WEST SUSSEX COUNTY COUNCIL CONSULTATION

TO:	Arun District Council FAO: Michael Eastham
FROM:	Stephen Gee, WSCC - Highways Authority
DATE:	11 March 2019
LOCATION:	Land east of, Tye Lane, Walberton, Arundel
SUBJECT:	WA/95/18/RES Approval of reserved matters following outline consent WA/44/17/OUT for the erection of 175 No. dwellings, car parking including garages, internal access roads, footpaths, parking & circulation areas, hard & soft landscaping, allotments, play areas/equipment & community orchard & other associated infrastructure & engineering works. This application may affect the character & appearance of the Walberton Village Conservation Area. Amended layout plans received.
DATE OF SITE VISIT:	
RECOMMENDATION:	Objection / More Information / Modification
S106 CONTRIBUTION TOTAL:	£ See below for breakdown.

Site Layout

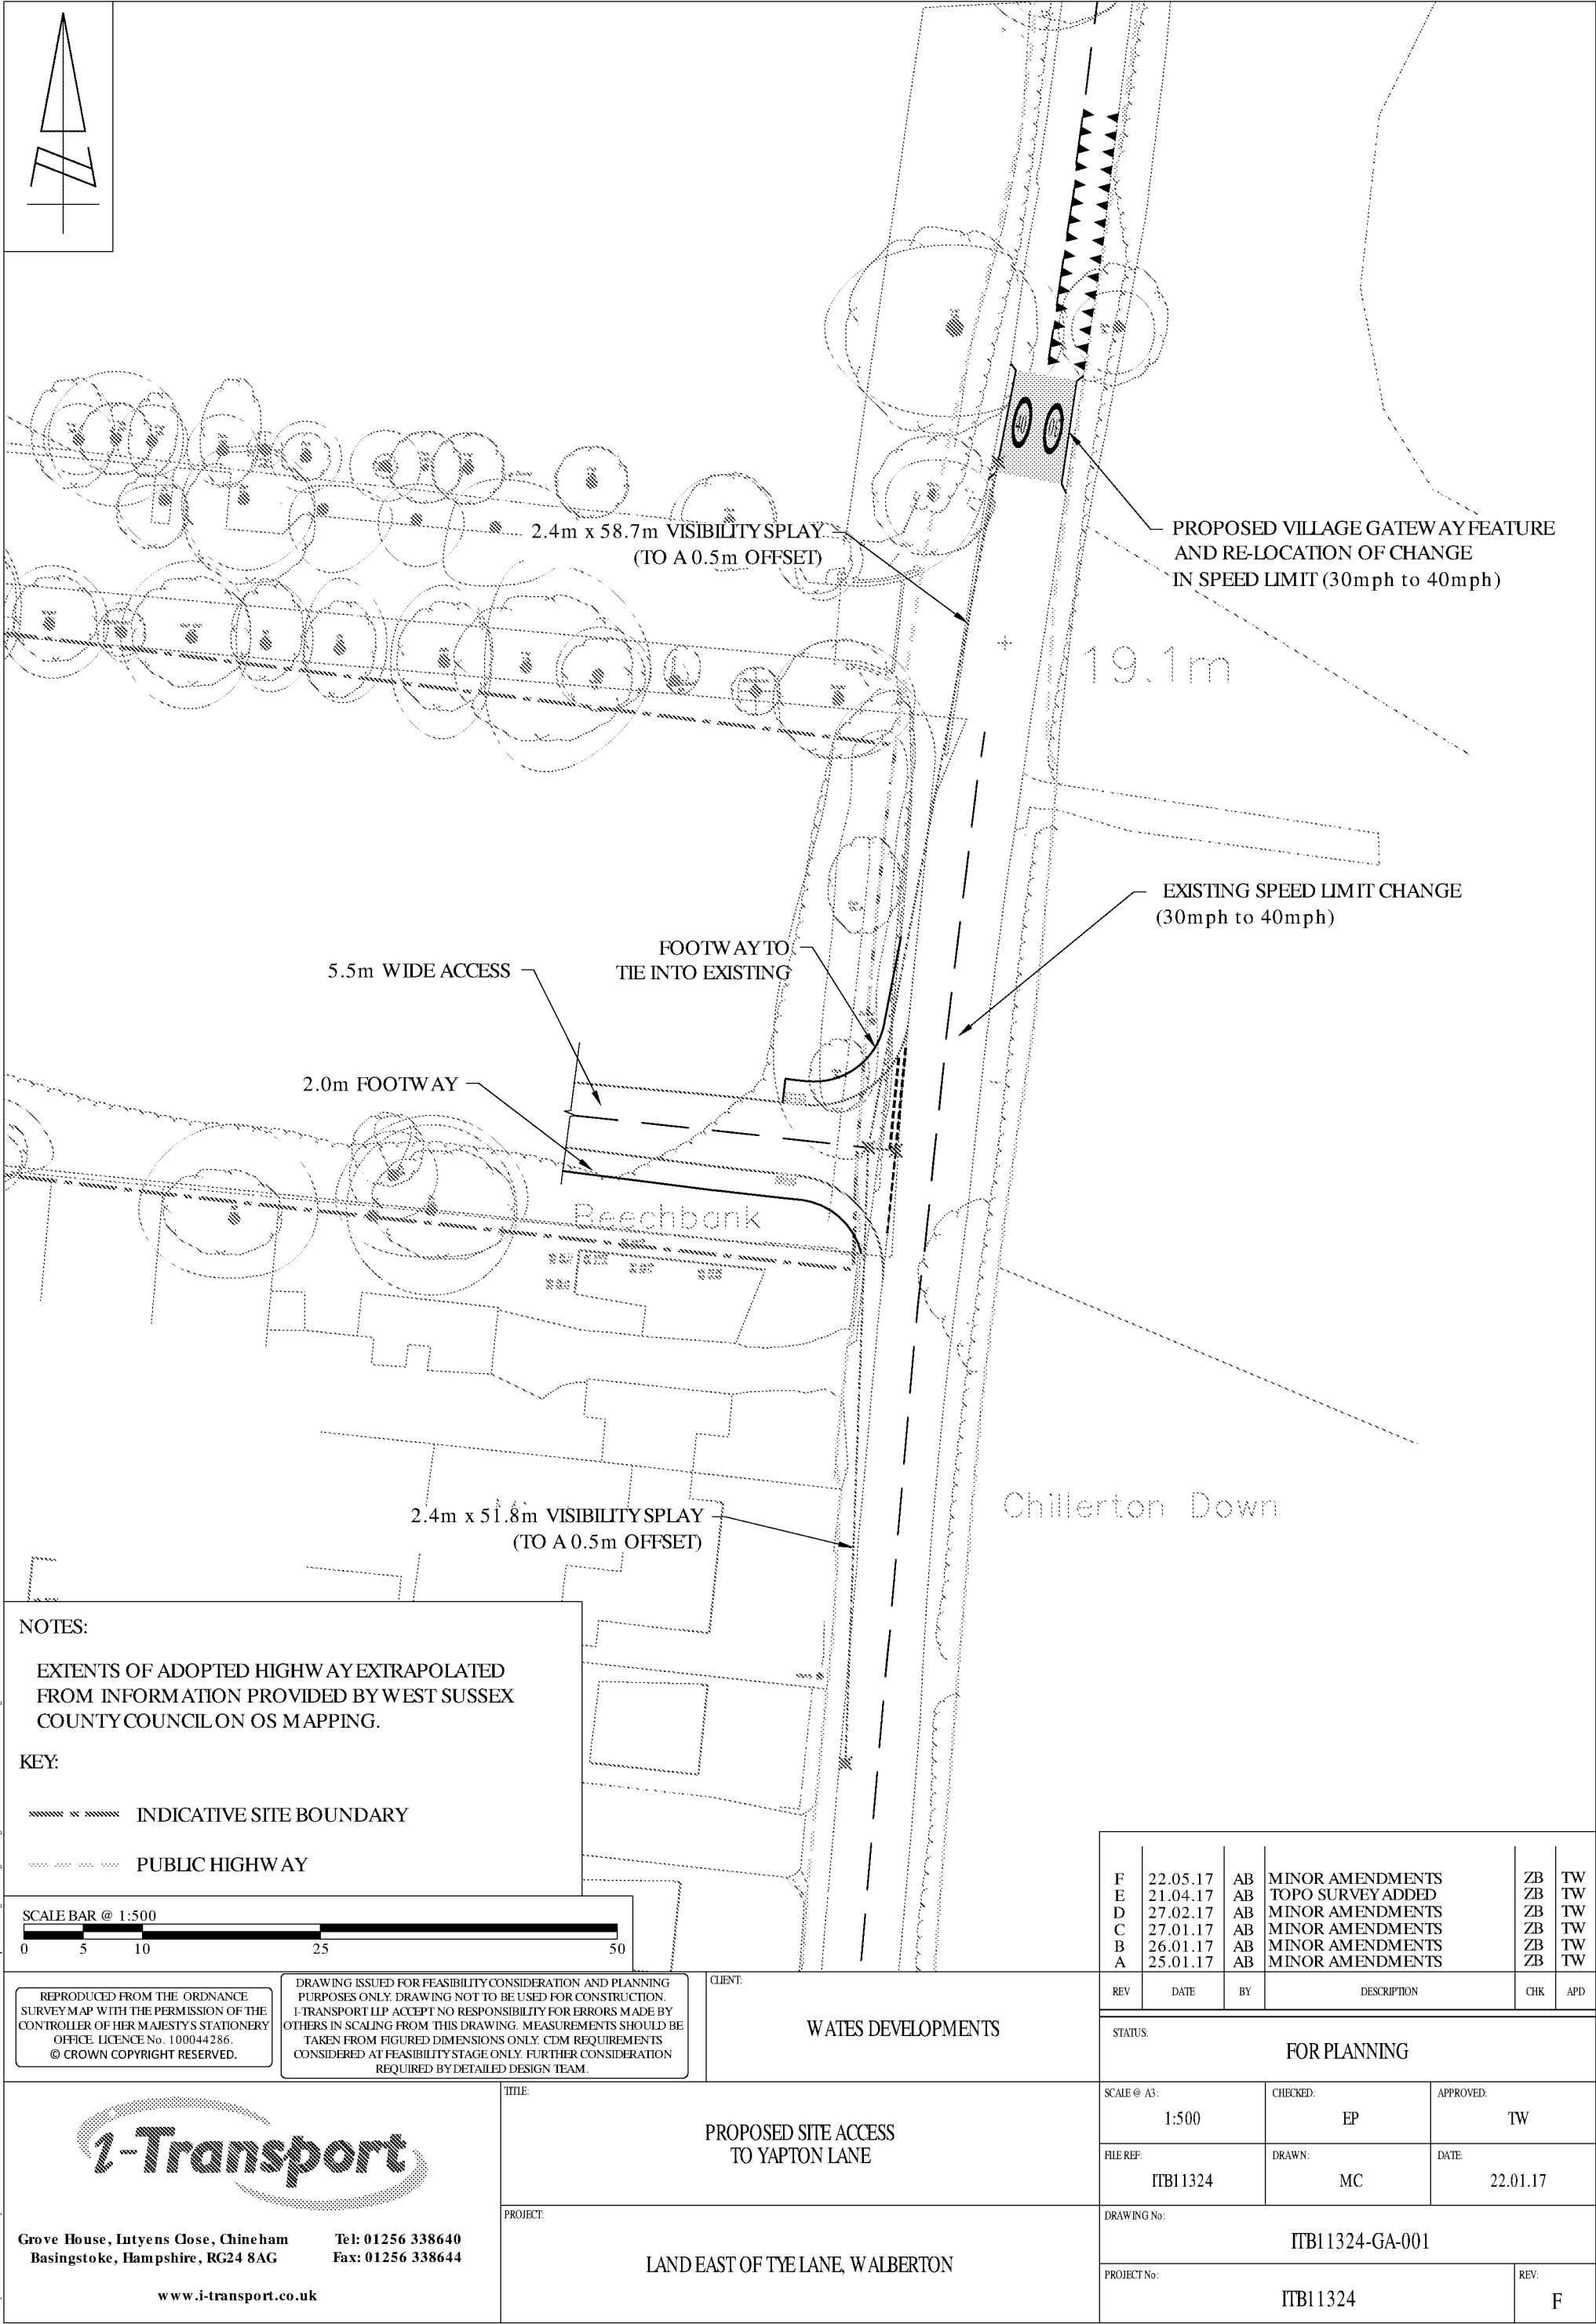
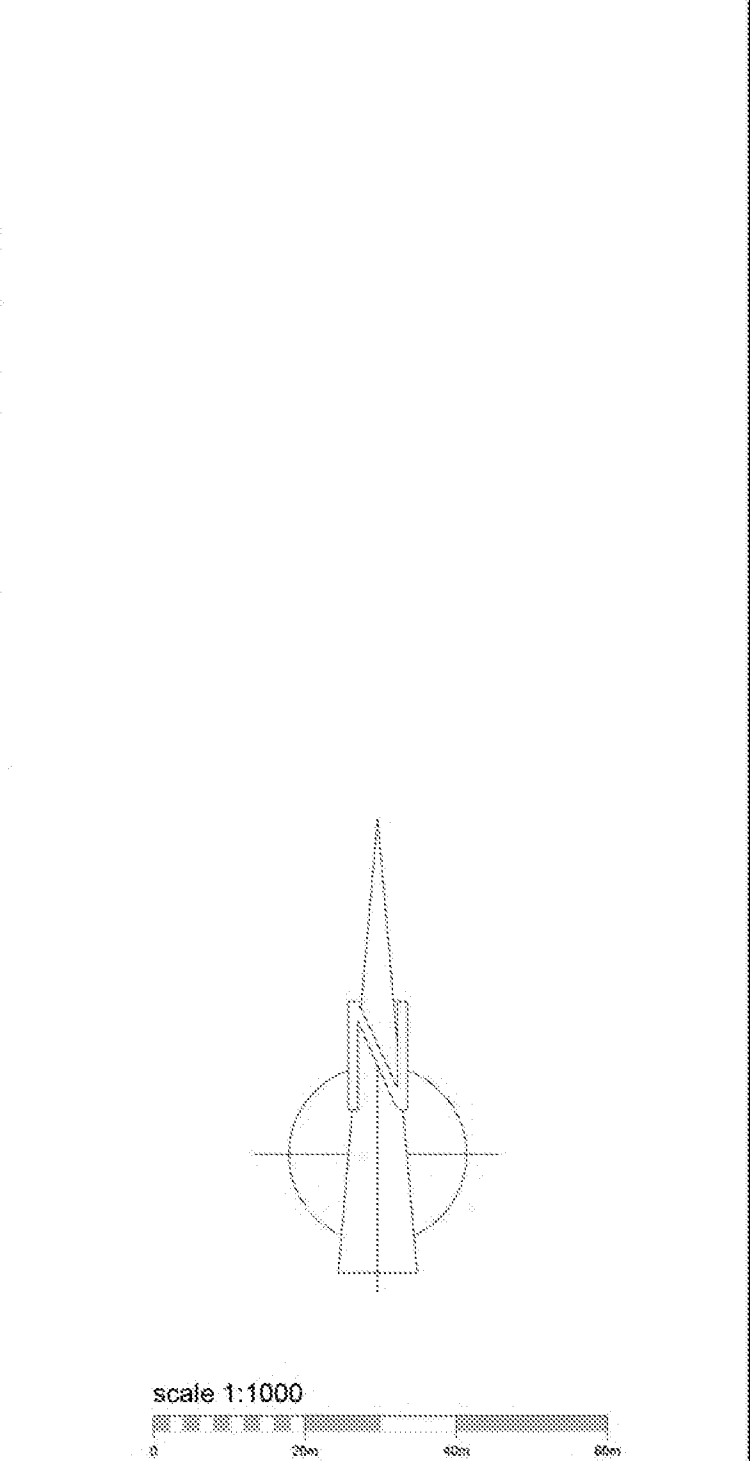
The reserved matter application proposes the following links (as shown in Site Layout SL01 REV C)

- A link to FP333, Avisford Park Road is now to be provided, the link is shown as an informal unsurfaced link. I would request that the internal link is appropriately surfaced to make it useable all year round and by all users.
- Pedestrian access to Tye Lane (see below)

The revised drawings show the removal of the emergency/pedestrian/cycle link to Tye Lane (towards the sites northern extent) and replacement with a pedestrian link to the southern extent of the sites boundary to Tye Lane.

The provision of the southern link is welcome however further details are requested on the width of the path to be provided and its appropriateness for use by cyclists.

- Details of the link to Tye Lane
- Appropriate surfacing of the link to Avisford Park Road.
- Details of the phasing plan and timing of connection points.
